RE: Submission – CBD and South East Light Rail Modifications (SSI- 6042 MOD 1)

This submission is prepared on behalf of Brookfield Commercial Operations (Brookfield), as the managing agent on behalf of the owners of 680 George Street, 50 Goulburn Street, 52 Goulburn Street, and 644 George Street, Sydney.

Figure 5.15 Indicative section – World Square stop

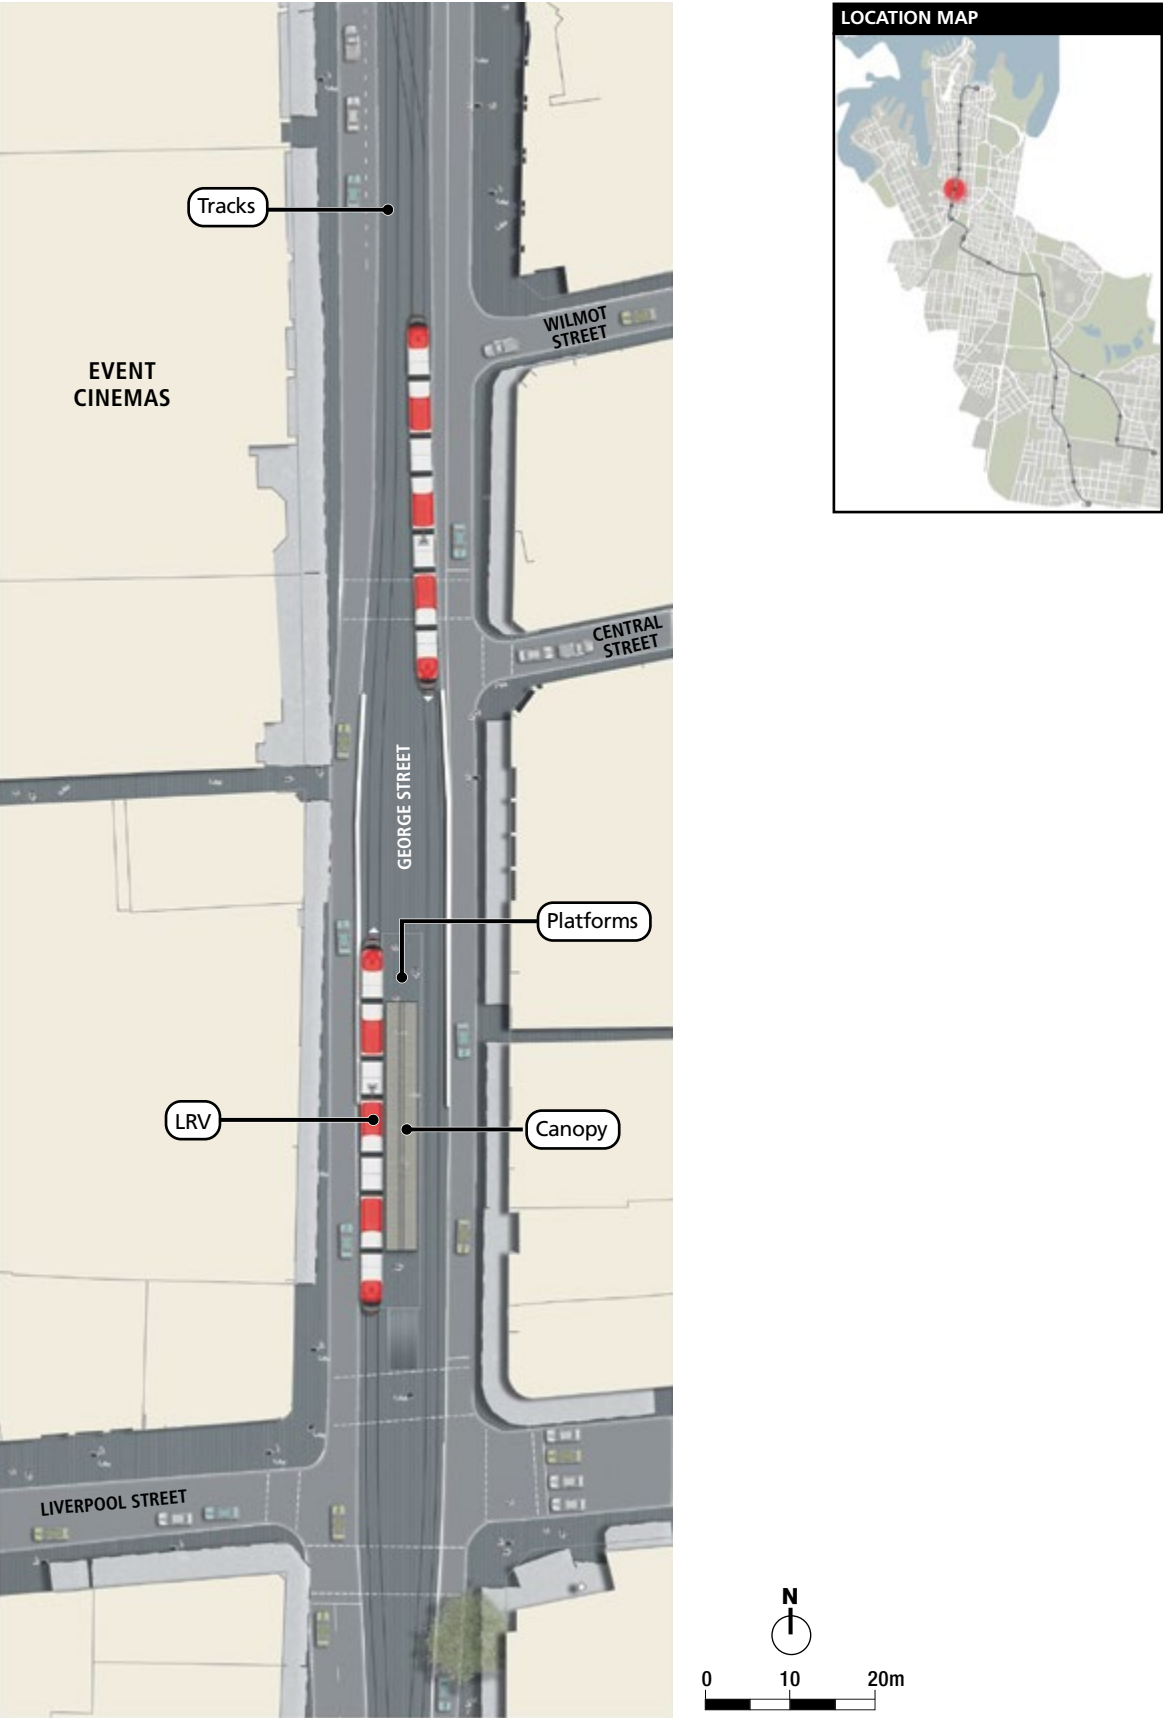
“the gradient of George Street at the proposed location of the approved World Square stop requires substantial street regrading to accommodate a fully Disability Discrimination Act 1992 (DDA) compliant stop. This includes the need to raise the Liverpool Street and George Street intersection and other changes to the existing level of the local road network including a number of retaining walls” – Modification Report Page 14

The gradient of George Street at the World Square location has been known since the original SSI application. The EIS included within the original SSI Application noted that for stops located within road corridors, access ramps were designed with a gradient of five per cent or less, or where the stop is constrained, ramps would be provided at a gradient of 1 in 14. The EIS further acknowledged the following:

As such significant work was undertaken to ensure that the proposed light rail stops could achieve, even in principle, DDA compliance. The original EIS outlined that the proposed locations of the some 20 stops along the CSELR were assessed against a wide range of criteria, and despite these engineering constraints it was determined that the demand for the World Square stop outweighed the additional cost for street and intersection regrading. The Modifications Report does not sufficiently explain the extent of works now required (and what

has changed since the original approval), and further does not investigate further options such as minor revisions to the location of the stop, compared to removing the stop in its entirety.

As such, we request that further information is made available to ascertain why the engineering works are now considered unachievable.

Whilst it is acknowledged that the approved location for the World Square light rail stop is not flat, it has to be detailed that removing an approved light rail stop at a significantly dense environment that does experience an incline, is not the best outcome to achieve a more accessible public domain. The demand for the stop exists, and as such equitable access should not be used as an excuse not to provide this service. We implore the NSW Department of Planning and Environment to oblige TfNSW and the City of Sydney Council to investigate options to ensure that the required light rail stop at World Square achieves full DDA compliance.
